RE: RESPONSE TO INFORMATION REQUEST FOR THE MAXWELL PROJECT (SSD-9526)

I refer to the NSW Department of Planning, Industry and Environment's (DPIE's) information request (dated 20 December 2019 and received via the planning portal on 6 January 2020). The DPIE's information request also included supplementary information requests from the Resources Regulator.

Figure 3-1

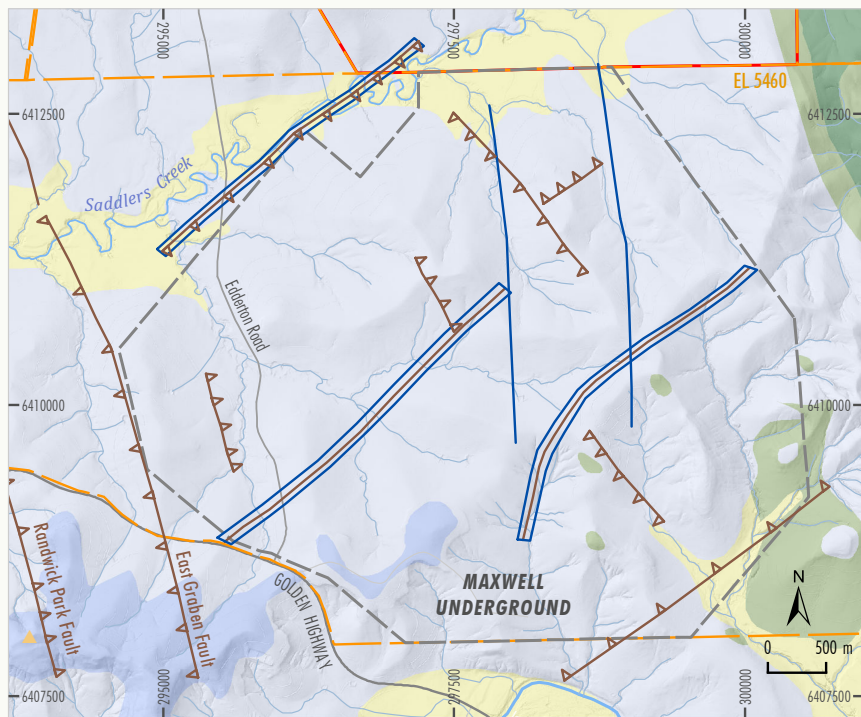
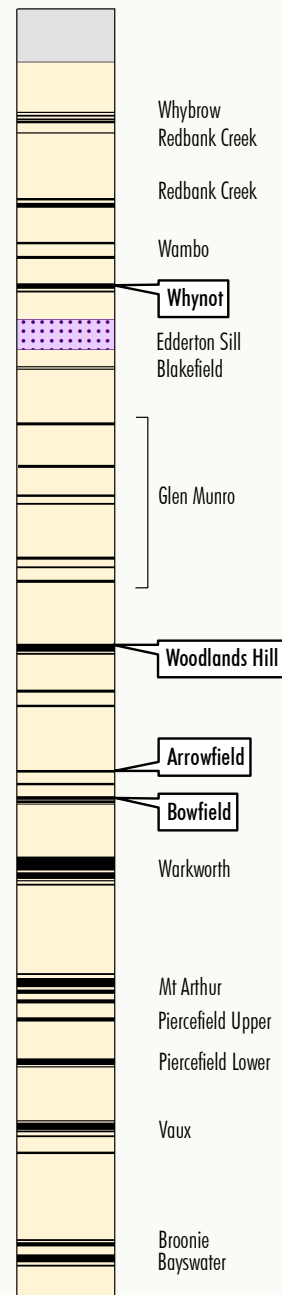
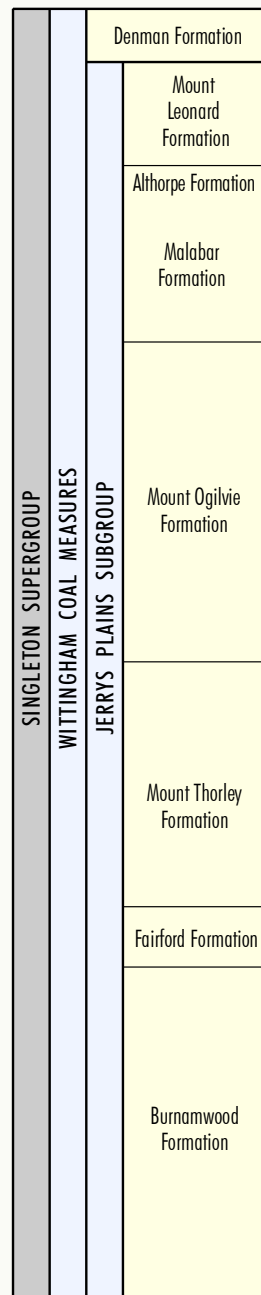
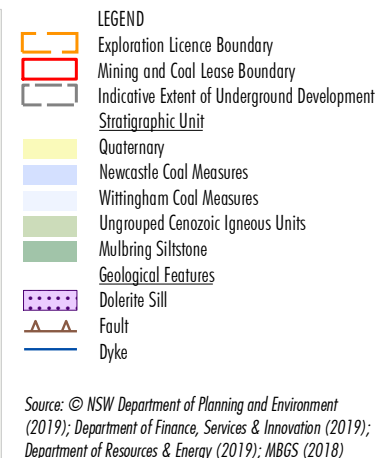
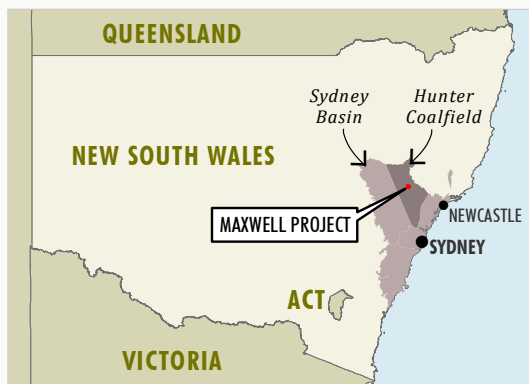
ID	Information Request	Response
	Figures	
9	<i>Please provide a high-resolution version of Figure 1-1 (Regional Location) from the EIS, preferably in JPEG format. Please include the locations of the Coolmore and Godolphin horse studs and Hollydene Estate on this figure.</i>	As requested, a revised version of Figure 1-1 showing the Coolmore Stud, Godolphin Woodlands Stud and Hollydene Estate has been provided to the Department of Planning, Industry and Environment.
10	<i>In Figure 3-1, there appear to be some geological structures (delineated with straight blue and brown lines) which are not identified in the legend. The Department requests clarification in this regard.</i>	The blue lines on Figure 3-1 represent 'known' igneous dykes and the brown lines represent 'known' faults. The brown lines enclosed by the blue lines represent the presence of 'probable' dykes in the vicinity of a 'known' fault structure.
